**From:** The Molloy's <Redacted>  
**Sent:** 01 June 2021 10:34  
**To:** Planning Enforcement <Planning.Enforcement@kirklees.gov.uk>  
**Subject:** 2020/62/90812/W - Disregard for Planning Consent

Subject: COMP/21/0286 6-8 Giles Street

NORTH EAST ELEVATION (Front)

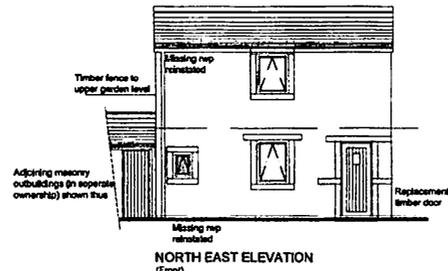
The front facing wall has been partially demolished and rounded. This should have been stated in the the planning application. The owners should have to apply for planning permission retrospectively, having changed the front facing appearance of their property in a conservation area without consent. This has been deliberately taken out of the application, as this changes the outlook in a conservation area - it was known that this would be rejected, it never being able to be replaced, and losing the original aspect of the road.

I have spoken to a conservation officer in the council, and she does not consider the installation of the CCTV and the alteration to the front wall, detrimental to the character of the listed building. I will however be warning the owners to submit a listed building consent application for any future works to the house.

SOUTH WEST ELEVATION (Rear)

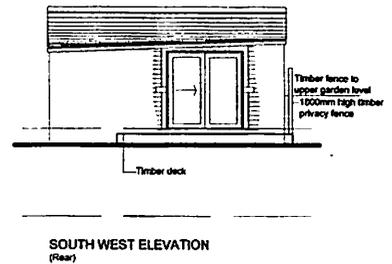
On the South Elevation (rear), the retaining wall was due to be stripped back and assessed on its stability. It was then due to be built up to 1100mm with stone copings on top.

I am not sure what assessment has been made of this wall, however we have seen considerable movement of wall debris inside our sheds since the building works commenced. We see no evidence of stone copings, either. We are not clear whether the wall has indeed been built up and stabilised, or the agreed stone copings added.

If you can assure me that the revised wall has been assessed by your planning dept.; that it has been adequately retained, with the copings atop; and that the owners are responsible for any subsequent damage to our property and any road users should our property collapse as a consequence of their building works (or lack of), then I am satisfied.

To exacerbate Issue 1, the owners have built up the ground level of the rear elevation behind our property, placing more pressure on the 'retaining wall' and our property. This was certainly not in the planning application - the Deck Area in the plans merely extended to the rear of number 6, not to the back of our shed properties.

The owners have then built a dwarf fence and can now overlook not only the road, but directly into what was our private seating area opposite. This is not at all in keeping with this road, and has ruined its outlook. There needs to be privacy redressed - for our property opposite and road users from the open nature of the outlook.

Potentially a 2m fence above the re-built wall will suffice for the perimeter of the garden facing the road and the new parking (from the height of the new decking area); or the removal of the extended decking area that has not been

In terms of 6 Giles street, the decking area is not in the conditions of the decision notice; it does not say that the seating area must be contained behind the property, and unfortunately, we cannot enforce upon annotations on submitted plans. Though the 1800mm fence should ideally be erected to allow the development to be in accordance with the submitted plans, again, this is considered to be *di minimis*, meaning it is so minor to not have any legal consequence. Equally, the area where the seating area was previously paved and the only difference is that they have put some gravel down and created a seating area, which is not considered development.
